**From:** Tom Errico <thomas.errico@tylin.com>  
**To:** Helen Donaldson <HCD@portlandmaine.gov>  
**CC:** David Margolis-Pineo <DMP@portlandmaine.gov>, "Earley, Katherine" <KAS@portlandmaine.gov>, Jeremiah Bartlett <JBartlett@portlandmaine.gov>, "Tarling, Jeff" <JST@portlandmaine.gov>  
**Date:** 2/2/2016 4:14 PM  
**Subject:** 65 Munjoy Street - Final Traffic Comments

10 FIRST FLOOR & SITE PLAN  
 0 4'-0" SCALE: 1/4" = 1'-0"

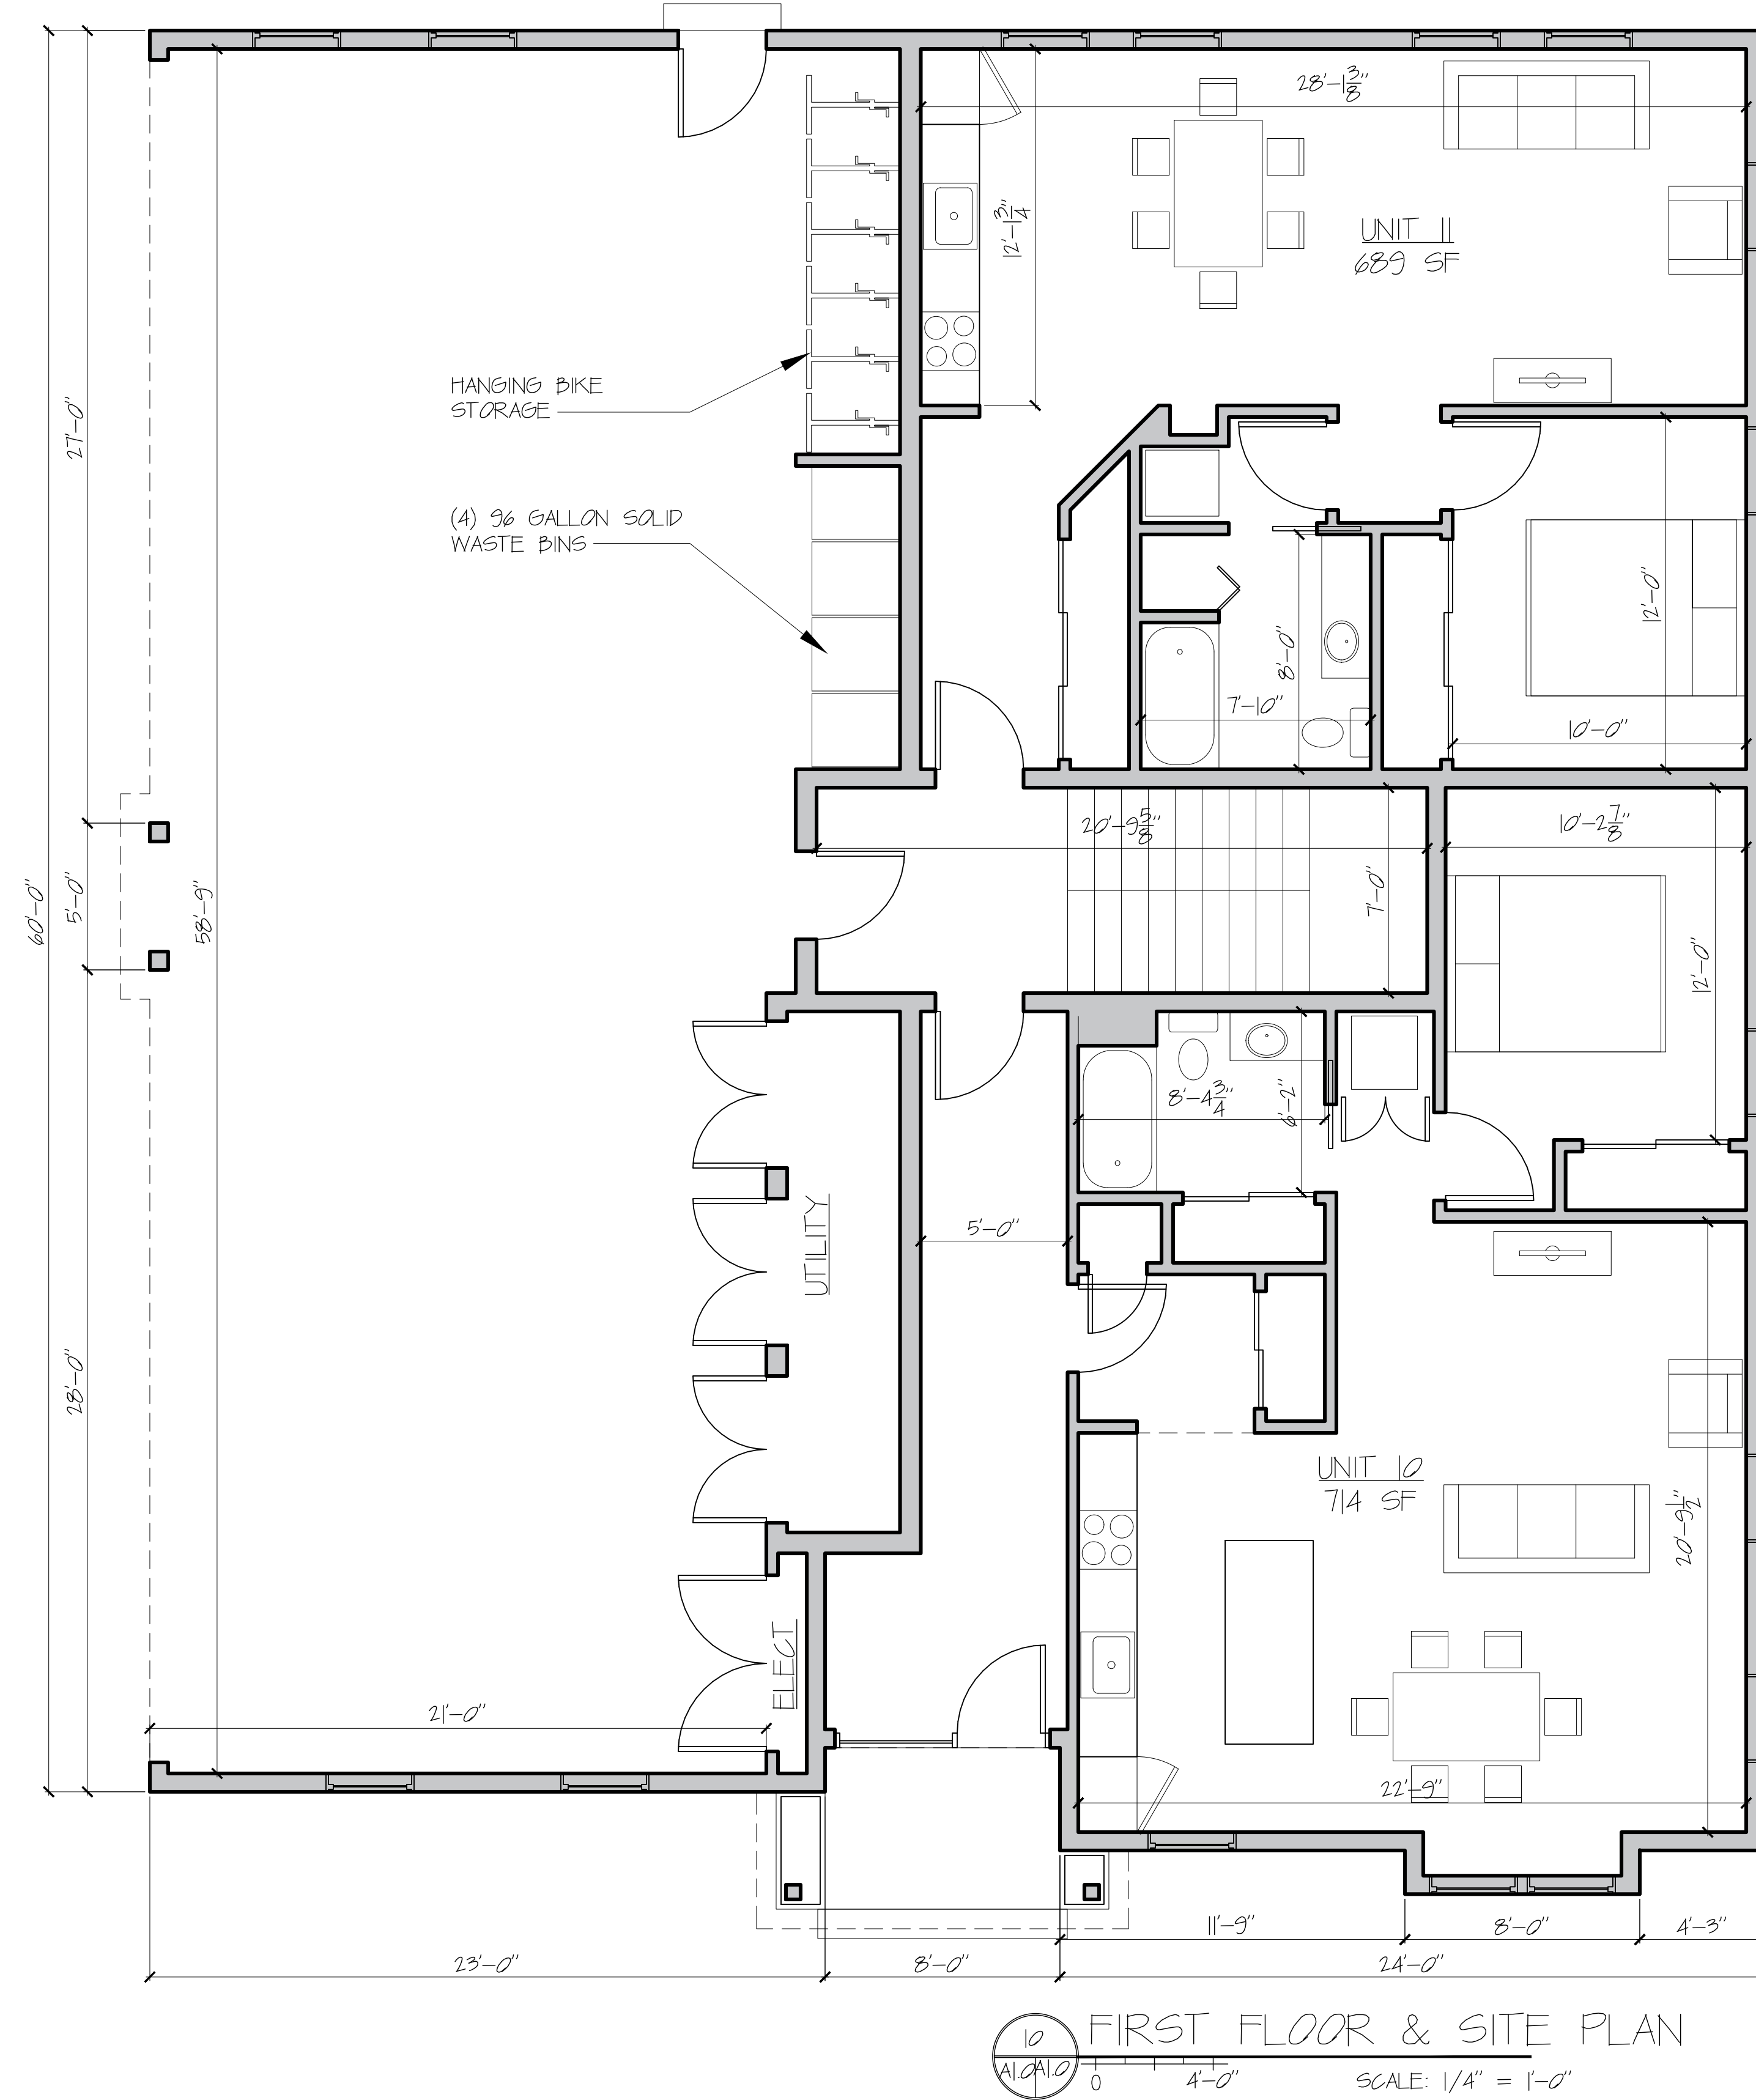
Hi Nell - I have reviewed the revised site plan and I find conditions to be acceptable. I would note that the applicant and I met on-site to simulate parking maneuvers and accordingly the aisle width was increased based upon our test. Additionally, the narrow parking space was relocated from the building column. I have no further comment.
